Planning Inspectorate Ref:
EN010112

Conwy County Borough Council Ref:
ENQ/31314

**Application by Awel y Môr Offshore Wind Farm Limited for an Order Granting
Development Consent for the Awel y Môr Offshore Wind Farm project**

Written Representation by Conwy County Borough Council

FIGURE NUMBER:
Figure 64a

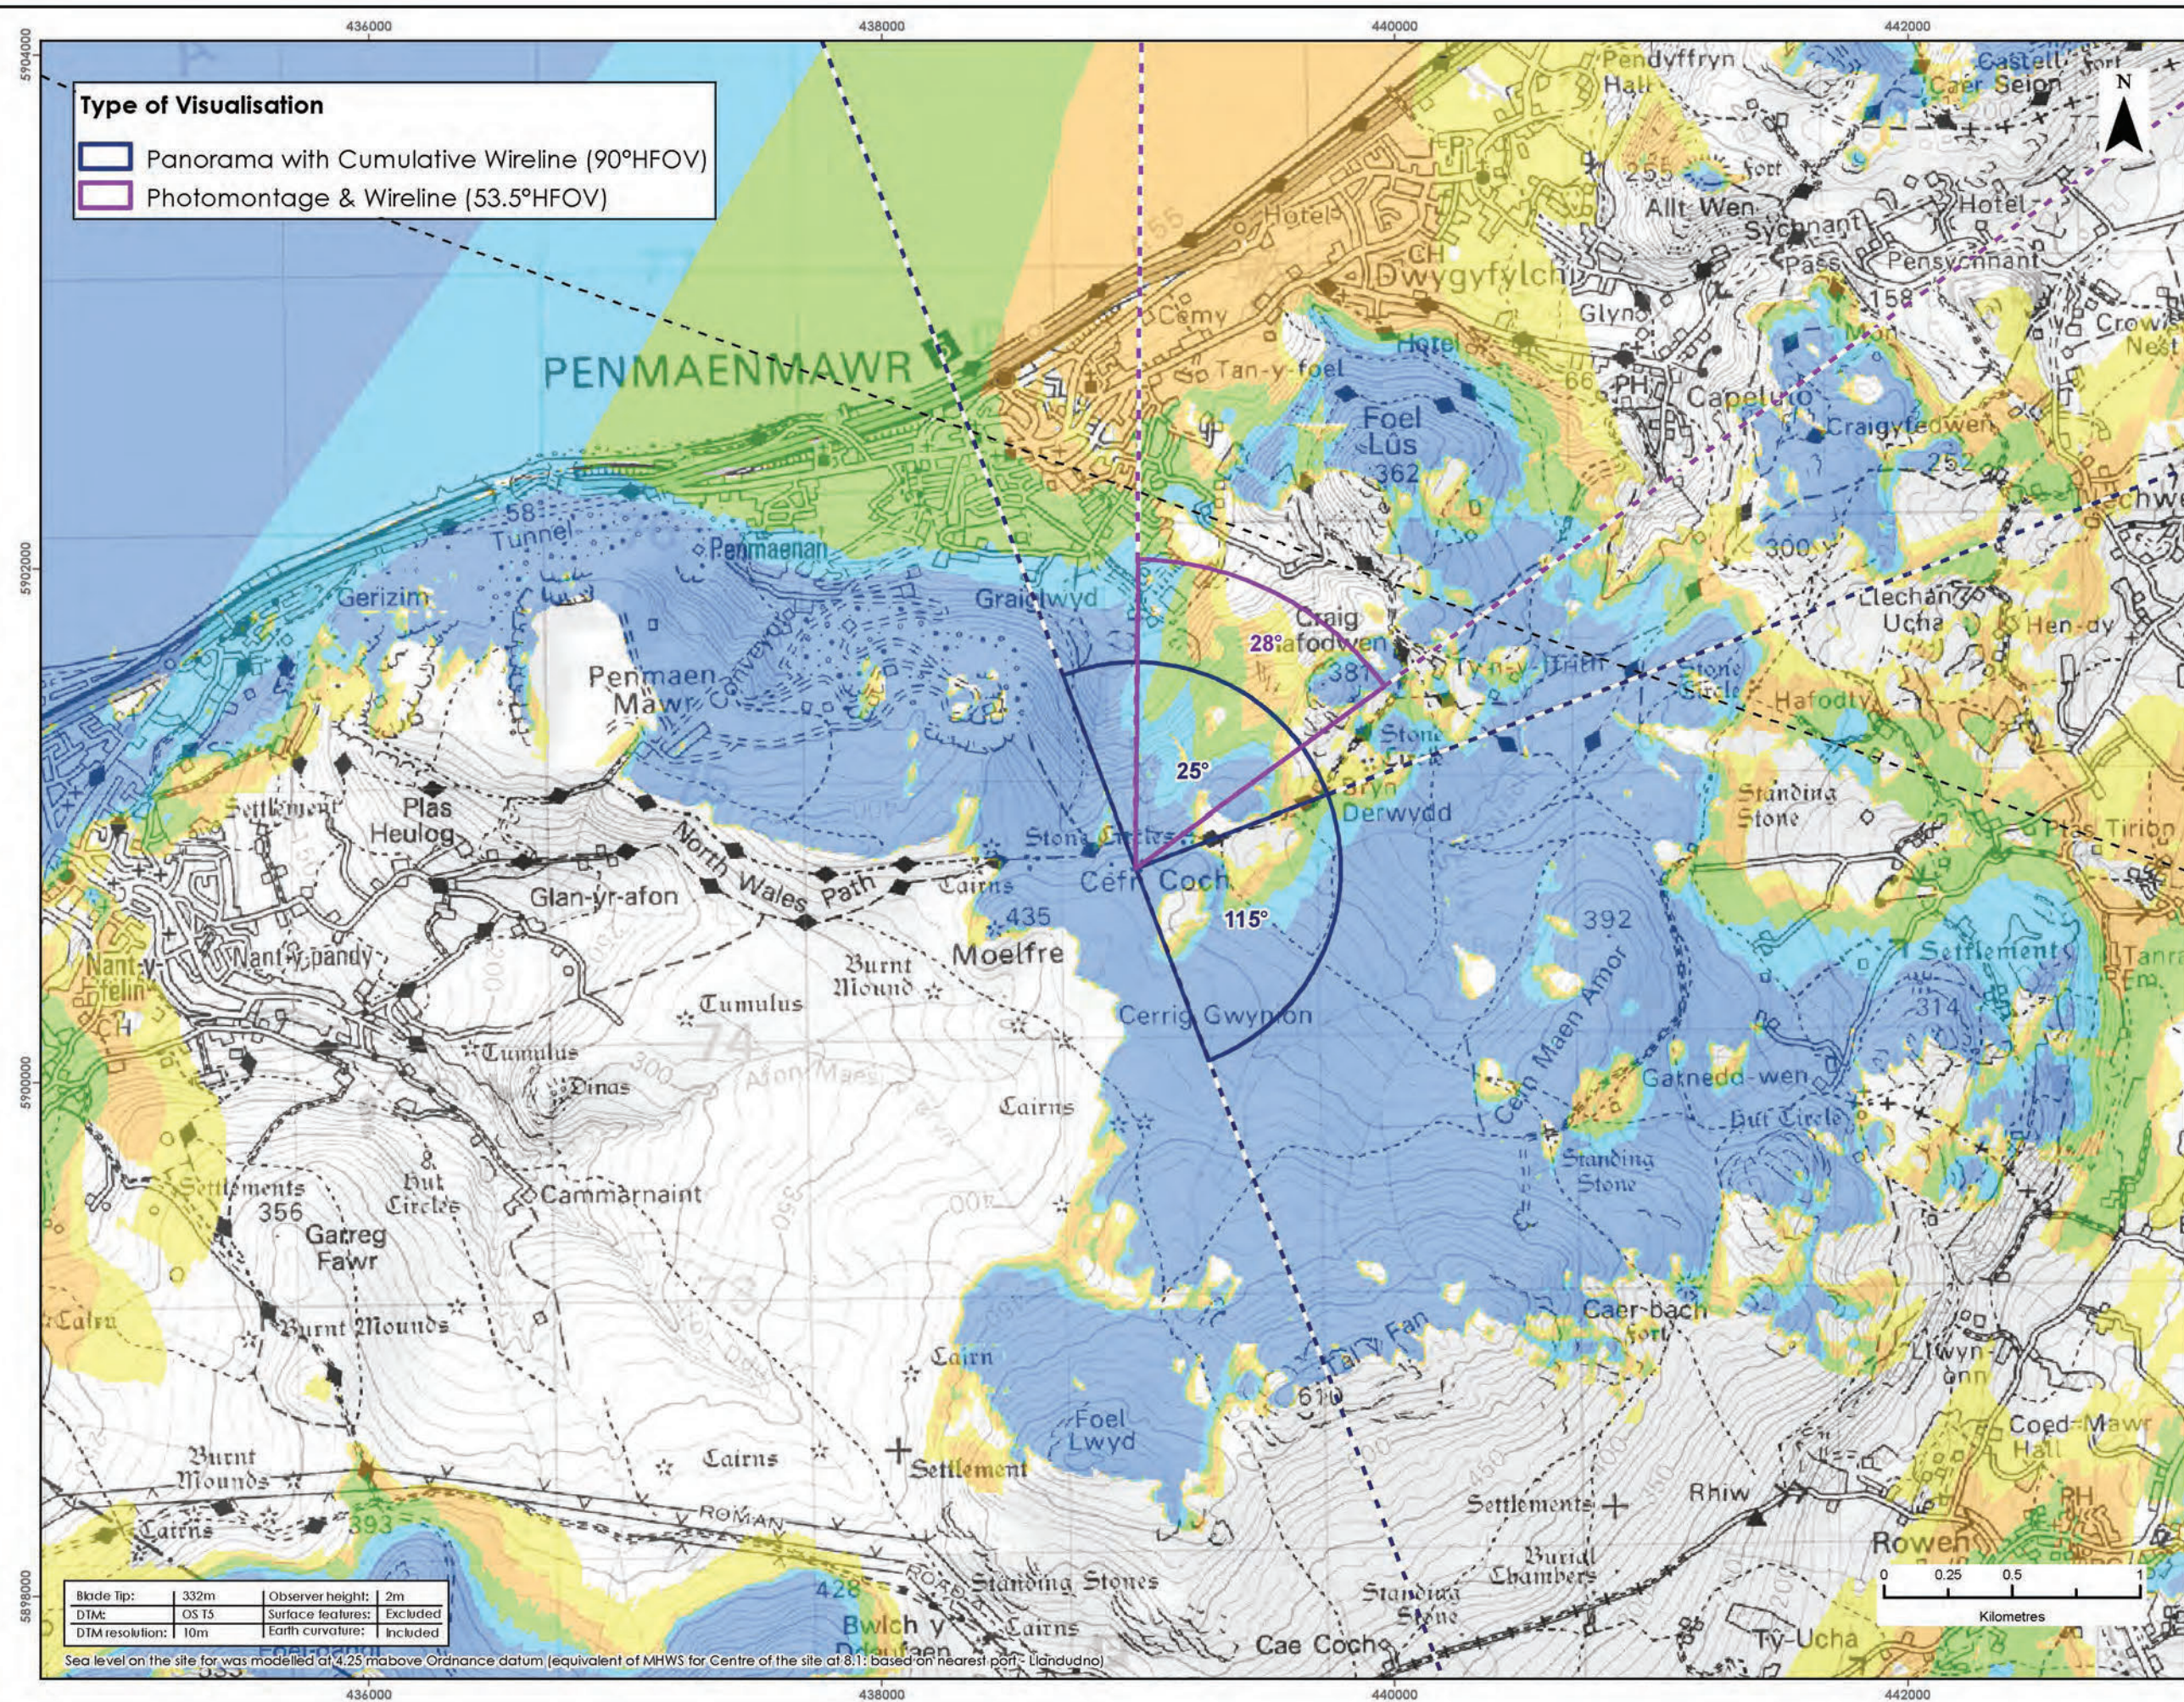
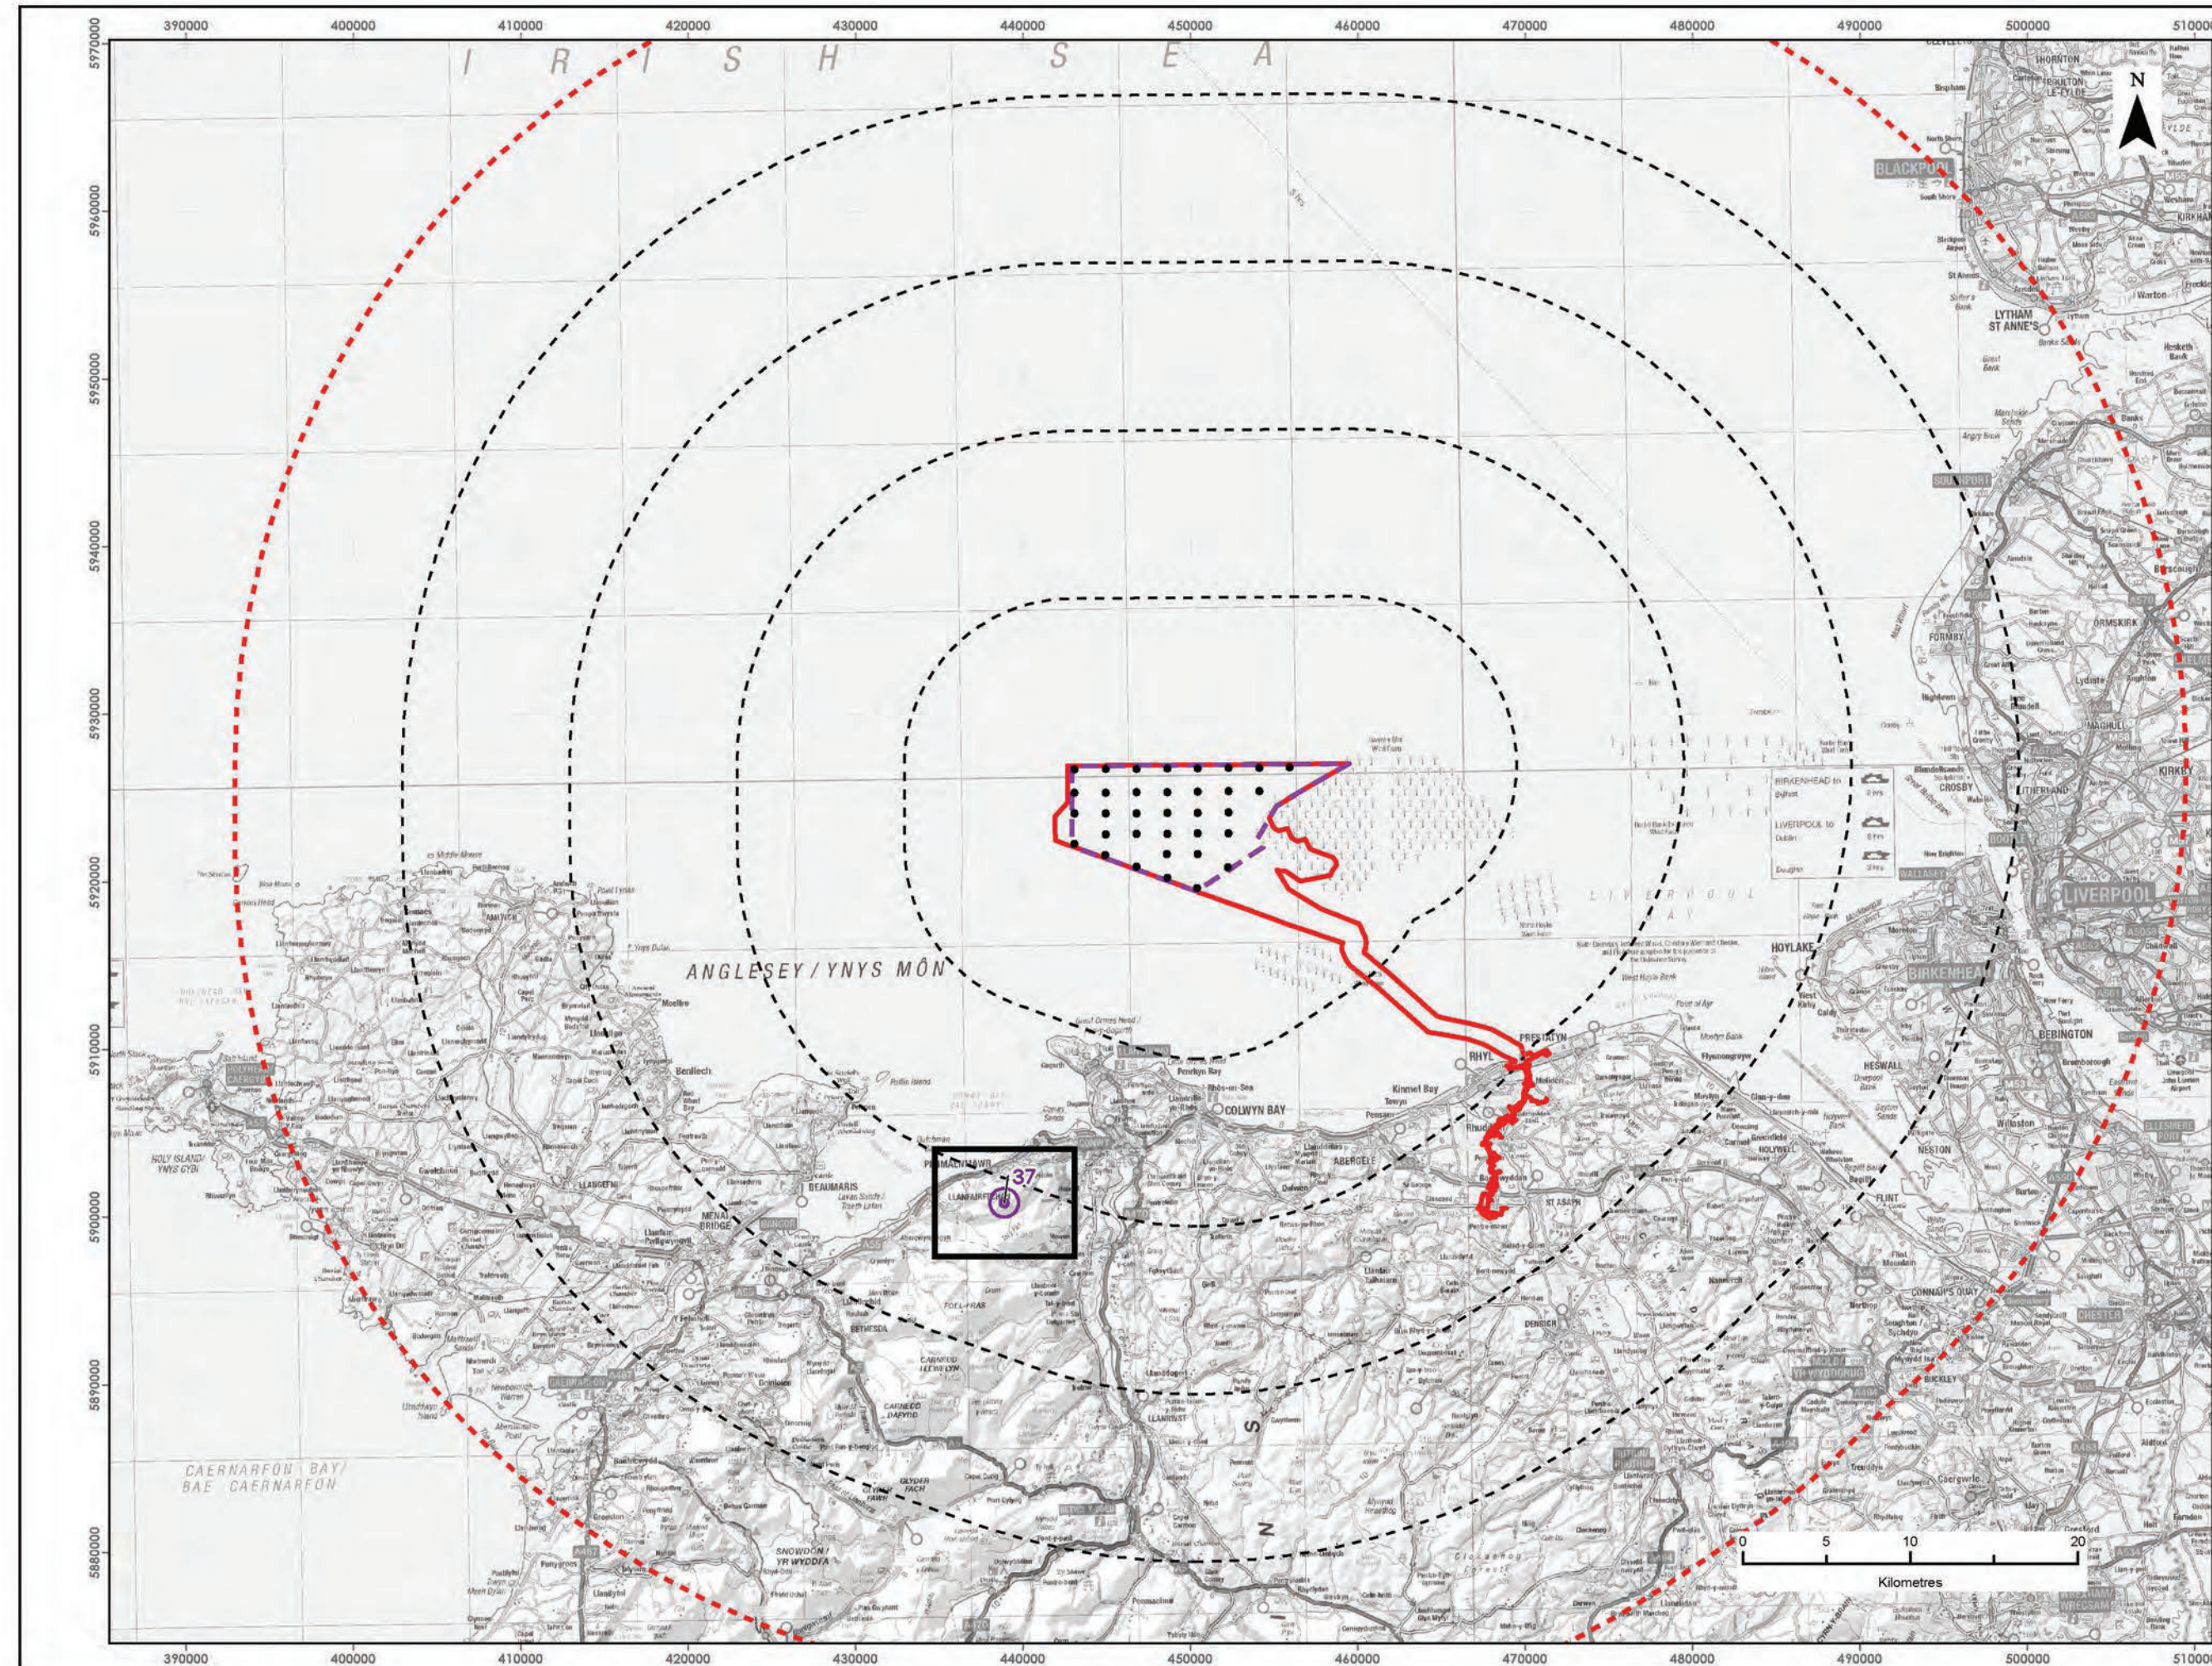
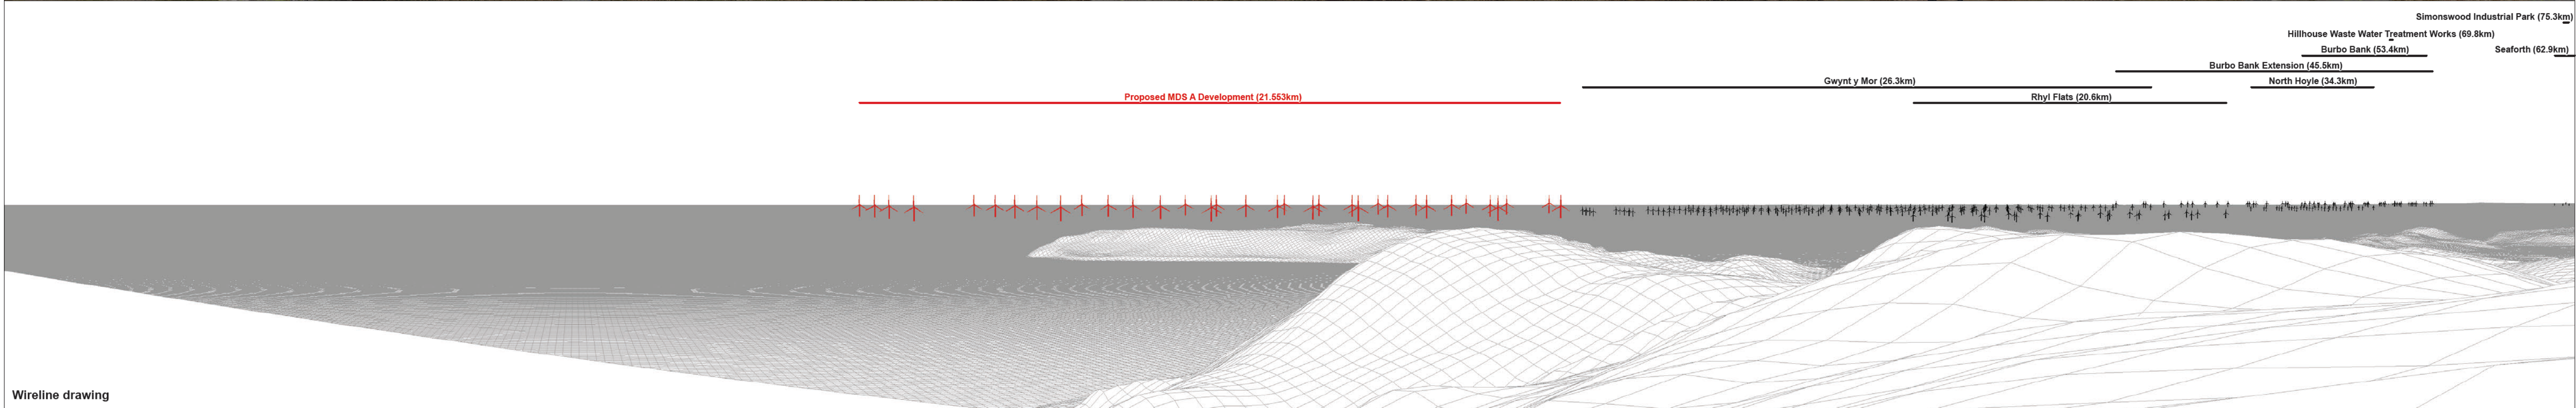
Figure 64b: Cefn Coch stone circle (23.895km)
